Your Ref
AL/70/11/
Our Ref
S/AR/2011/70
Date: 03/08/2011

Proposal: Outline application for demolition of all existing buildings and replacement with 940 square metres of B1 commercial development together with associated service area parking for 40 vehicles and landscaped amenity space.

Site: Woodgate Centre, Oak Tree Lane, Woodgate, Chichester, West Sussex PO20 3GU.
AL/70/11/

**WOODGATE CENTRE, WESTERGATE
for Builtform Developments Limited
INDICATIVE MASTERPLAN**

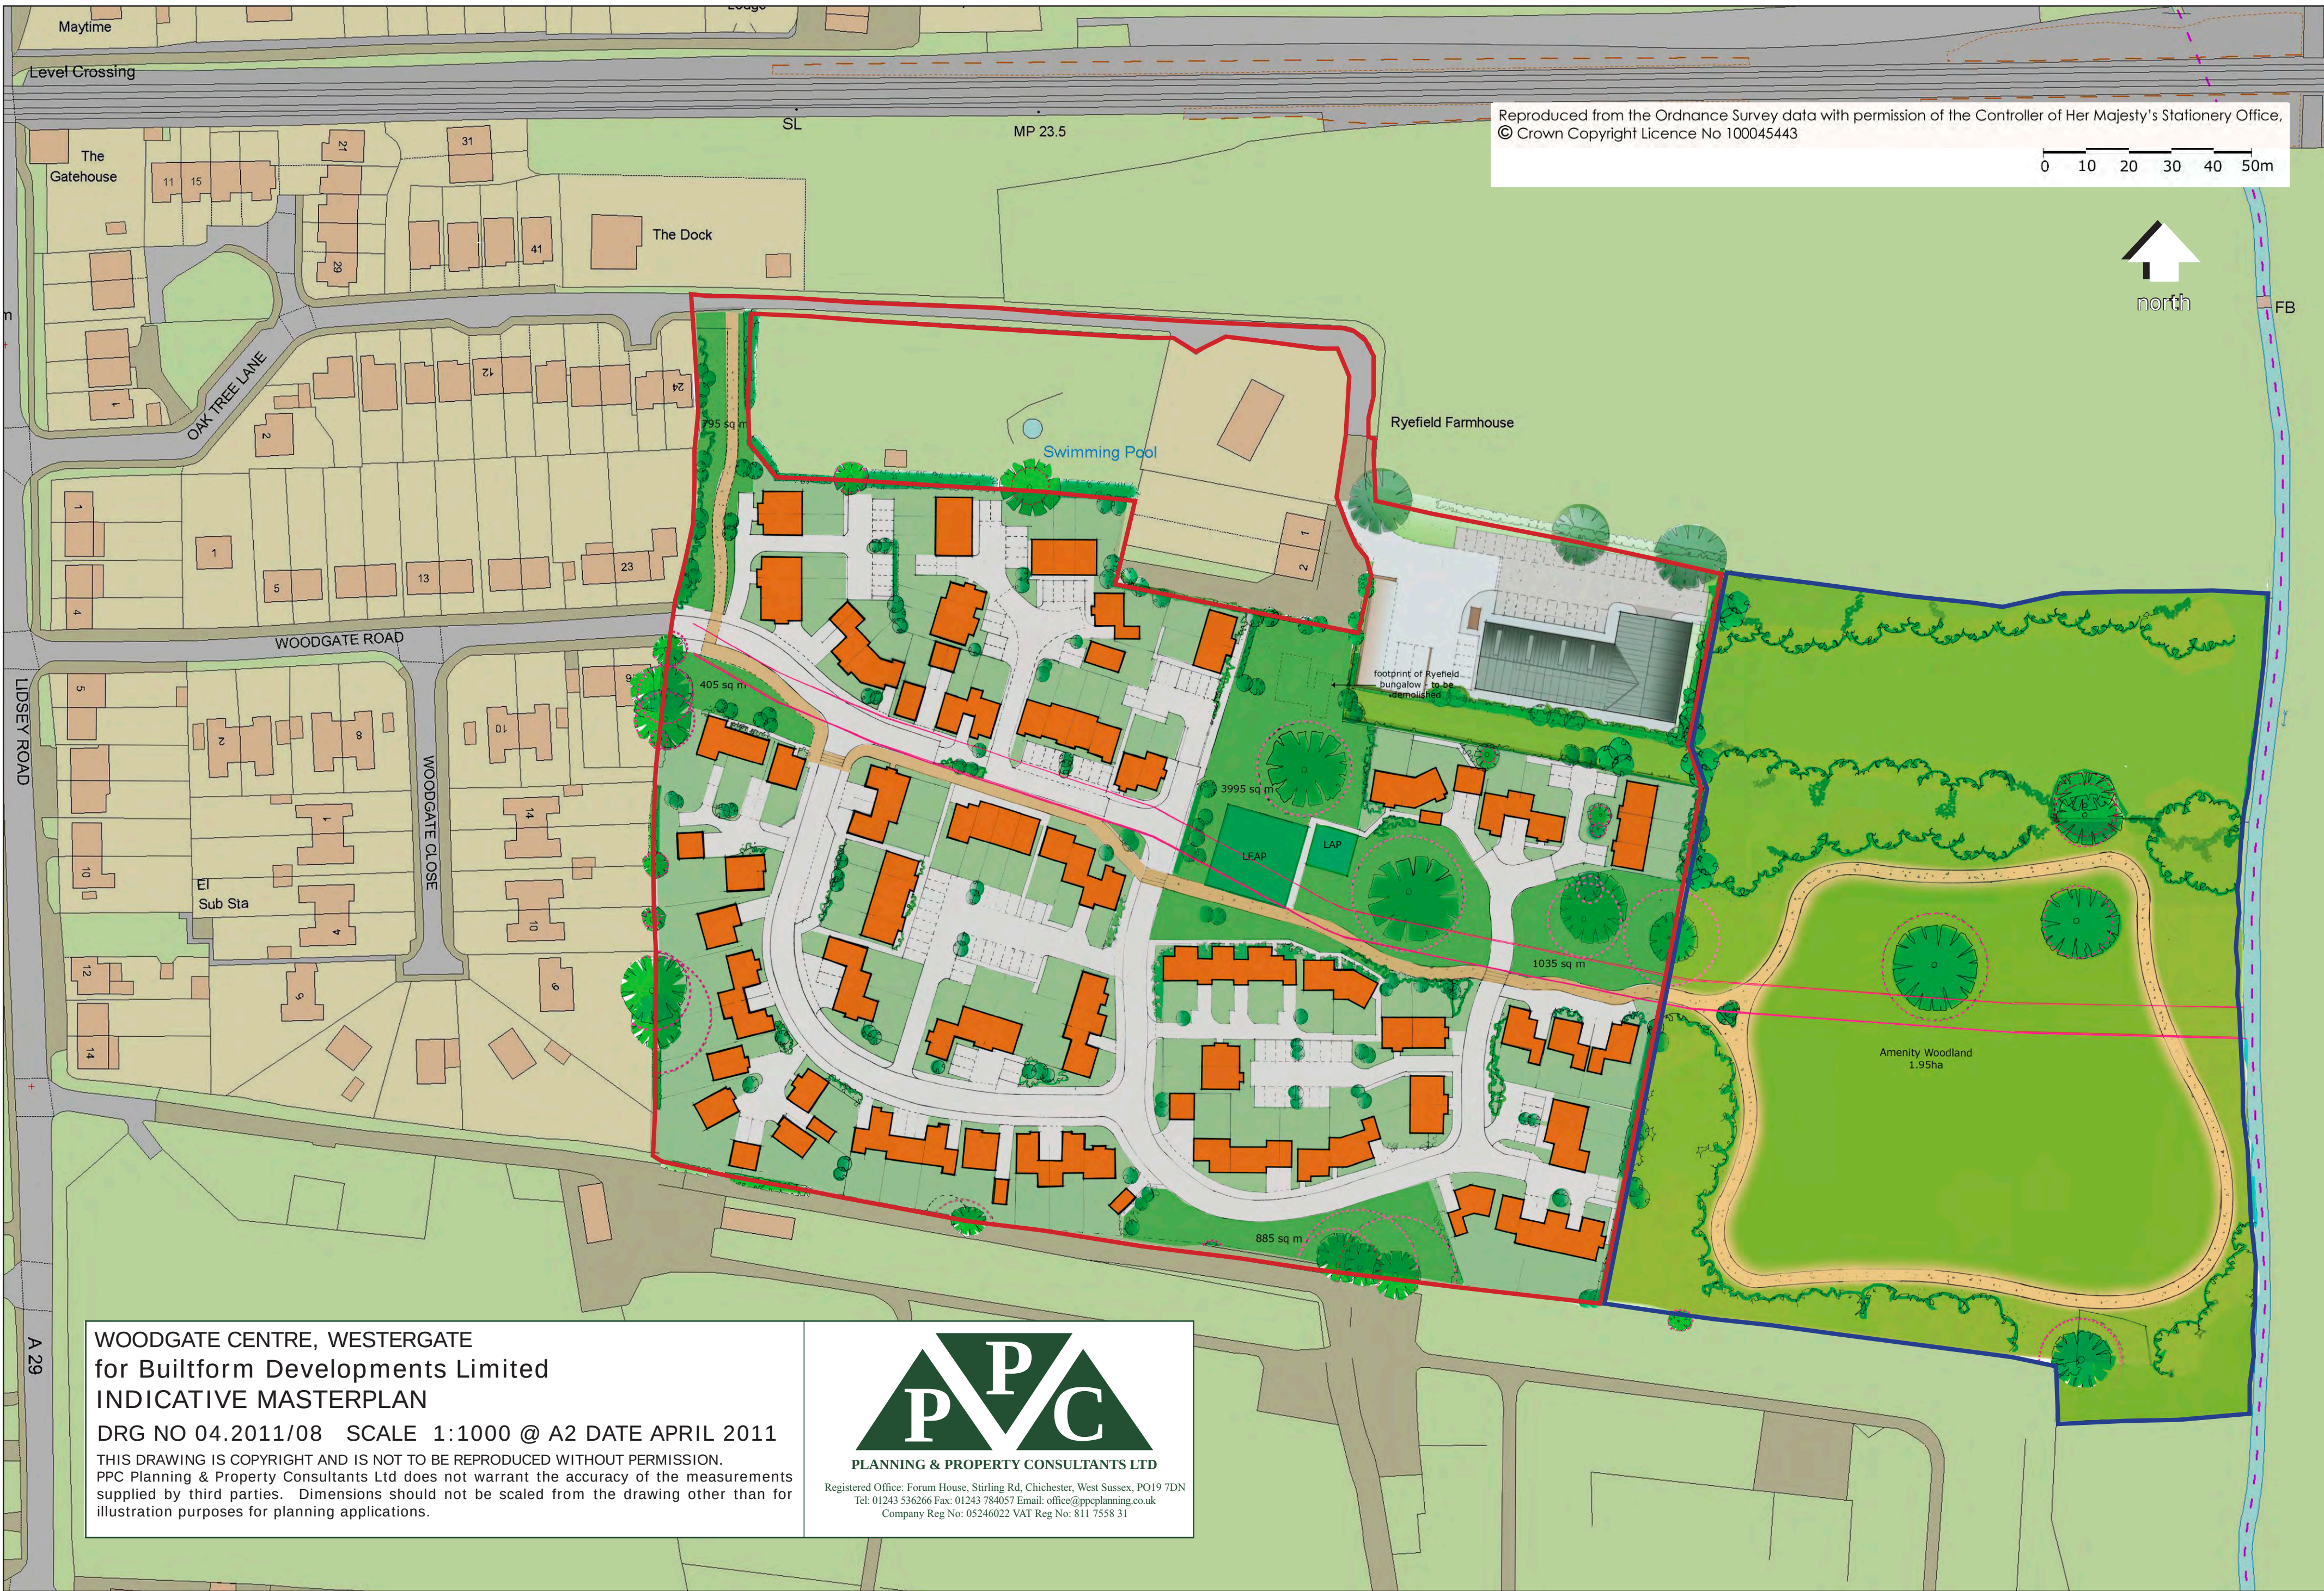
SUDS systems usually have a significant land take and it is not clear how the SUDS facilities can be accommodated within the proposed layout. Before the proposed layout is approved, we advise that the applicant/developer give consideration to ensure that the proposed means of surface water disposal can be accommodated within the proposed layout.

We request that should this application receive planning approval, the following condition is attached to the consent: "Construction of the development shall not commence until details of the proposed means of foul and surface water sewerage disposal have been submitted to, and approved in writing by, the Local Planning Authority in consultation with Southern Water".
